**Consultation Response from KC,
Trees**

2025/93235 The Cross, Wyke Lane/Cross Street, Oakenshaw

**Removal of the Cross and reinstatement within the grass verge on Cross Street/Wyke Lane
(Listed Building)**

Date Responded: 06/01/2026

Drawing Title General Arrangement and Detail Drawing

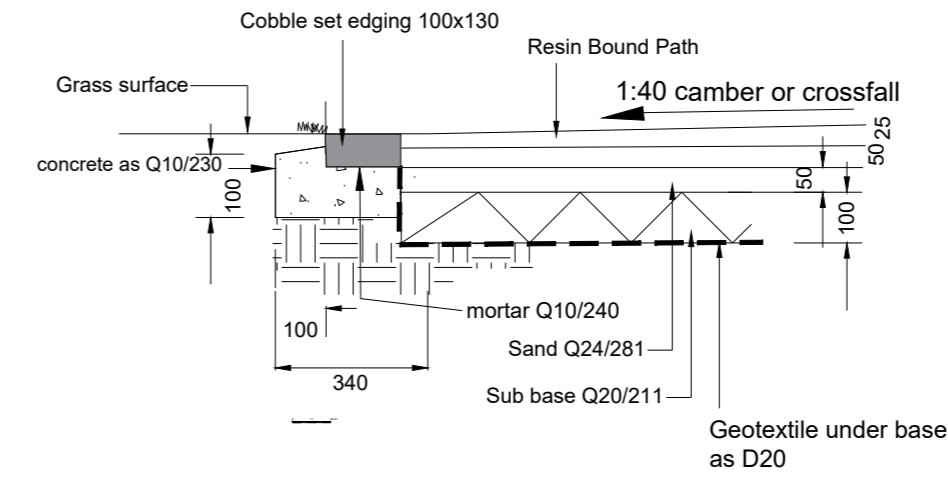
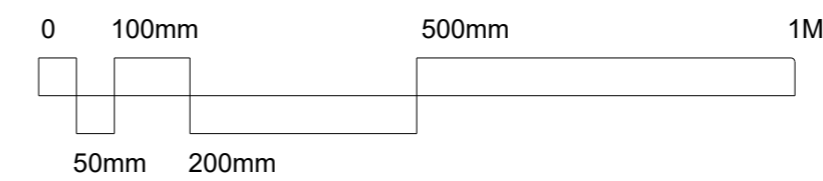
It is understood that the proposal is to relocate the Cross to the grass verge and install a footpath through the RPA of the cherry tree in this location.

There is a short section of existing footpath leading to an information board, which appears to be cemented into the ground at present. However, this installation appears to be recent, therefore it is unlikely that the roots of the cherry tree are adapted to compaction and disturbance in this area to such a degree to reduce likely the impacts of laying the new footpath.

The RPA should be offset from the pavement/road. The tree is likely to have rooted farther into the grassy area, and therefore a larger portion of the surface feeding roots are likely to be severed during the work. Additionally, it should be noted that cherry trees tend to have large surface roots and relatively shallow rooting systems.

BS5837:2012 *Trees in relation to design demolition and construction- recommendations* states that construction within the RPA should accord to the principle that the tree and soil structure take priority, and the most reliable way to ensure this is to preserve the RPA completely undisturbed. New permanent hard surfacing within the RPA of a tree intended for retention should only be constructed where it is considered unavoidable. In this case, the incursion is avoidable as it is possible for the cross to be accessed off Cross Street.

Therefore, KC trees advise that if the tree is to be retained, the proposal should be amended to avoid the RPA, as constructing new hard standing in this area is unlikely to be well tolerated by this tree and may contribute to its decline and a loss of amenity value.

However, if on the balance, the proposal is approved as shown, a no-dig method is recommended under arboricultural supervision, as stated within the JCA AIA ref. 23498/ChC. This method involves stripping the top 75mm of soil, as opposed to the traditional alternative of digging deeper to establish a solid base. This method will minimise root disturbance.

It should be noted that the existing installation and flagstones should be lifted by hand, and care should be taken during their removal to minimise disturbance to the rooting area by laying ground protection e.g. rubber matting. No heavy machinery may be allowed within the RPA of the tree if it is to be successfully retained.

An AMS should be submitted and agreed with KC Council ahead of the commencement of any works within the RPA. See AMS condition below:
